EA ref: PA-0005492/01
PINS ref: EN020009
18 June 2026

**Consultation on a Non-Material Change Application for the National Grid
(North London Reinforcement Project) Order 2014.**

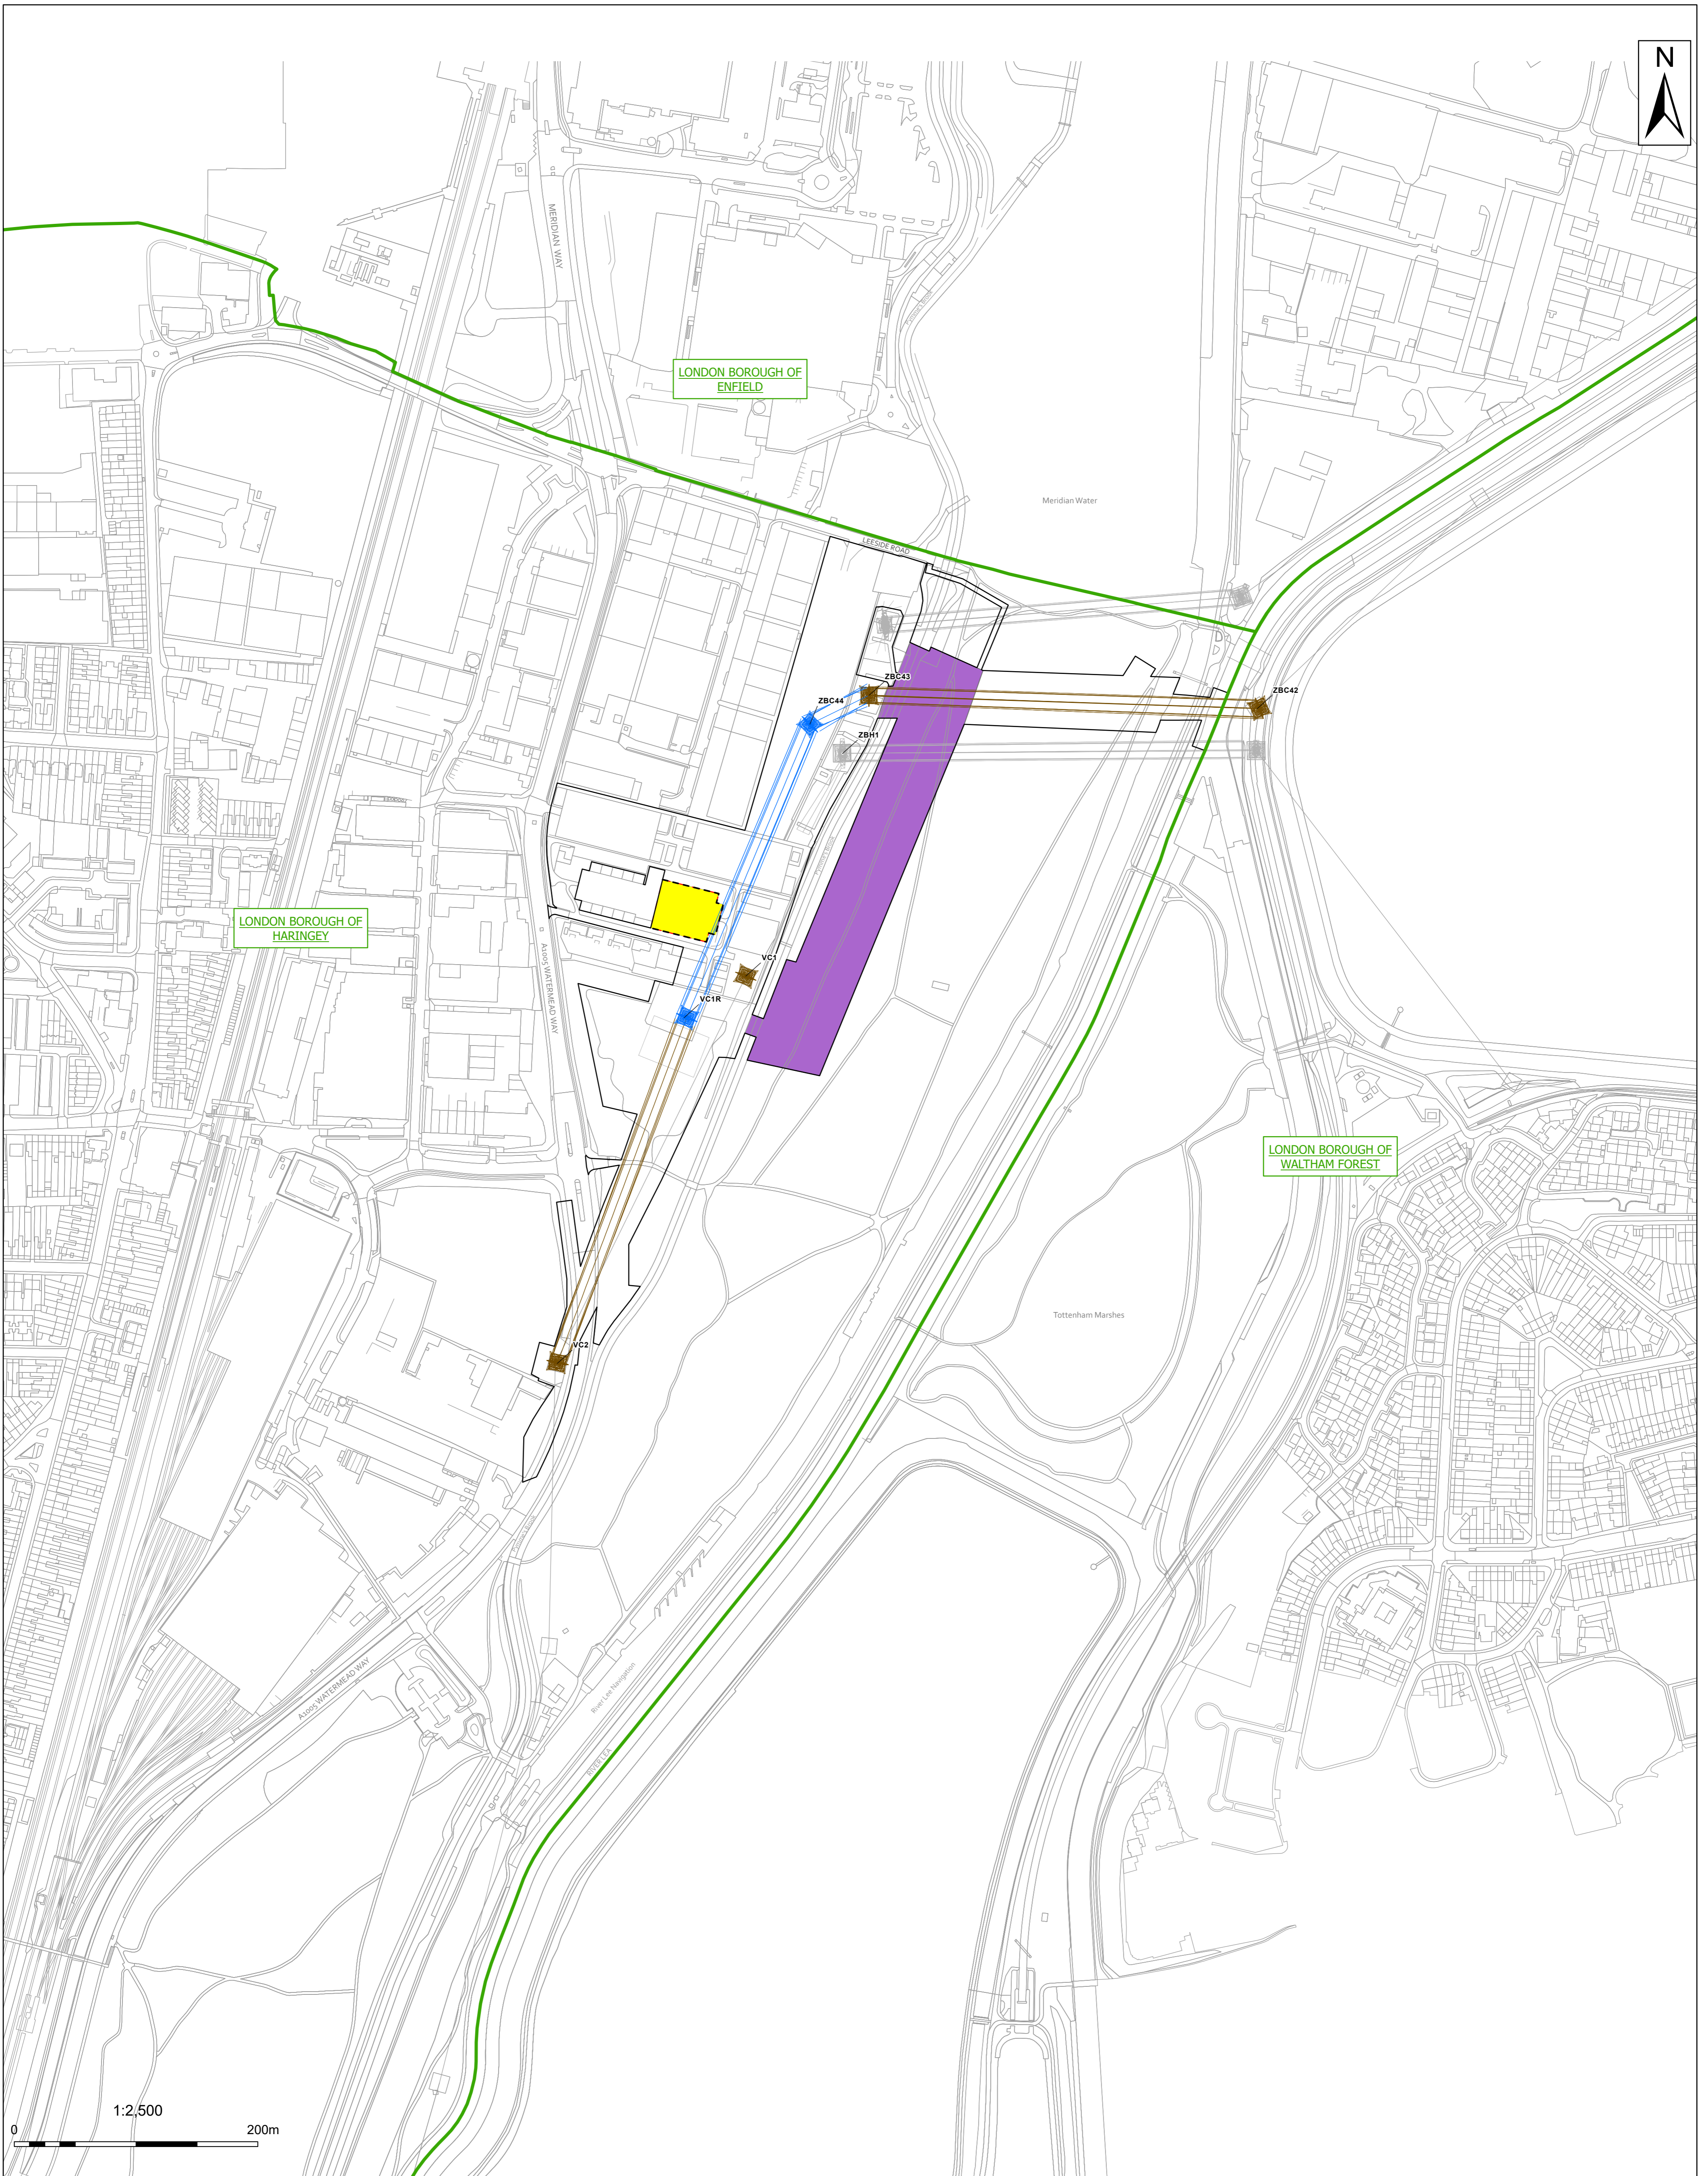
The proposed changes will require the installation of 2 new pylons, VCR1 and ZBC44. From the information reviewed, it is not clear where these will be located. The above notwithstanding, from information previously provided, the Environment Agency is aware that the wider Tottenham Substation (and former bus depot) are contaminated. While it is noted that there has been extensive remediation within parts of the site, without knowing the locations of the pylons is not clear if they will be in areas where significant contamination remains

It will need to be demonstrated that, with respect to contamination the locations of the pylons have been subject to sufficient assessment.

The use of piled foundations creates additional risk, particularly in locations where gross contamination which could be mobilised is present and where piling foundation penetrate the underlying London Clay.

Where piled foundations are proposed a suitable Foundation Works Risk Assessment will need to be completed. This should follow the process set out in Piling and Penetrative Ground Improvement Methods on Land Affected by Contamination (available here [CL:AIRE Technical Guidance - Page 2](#))
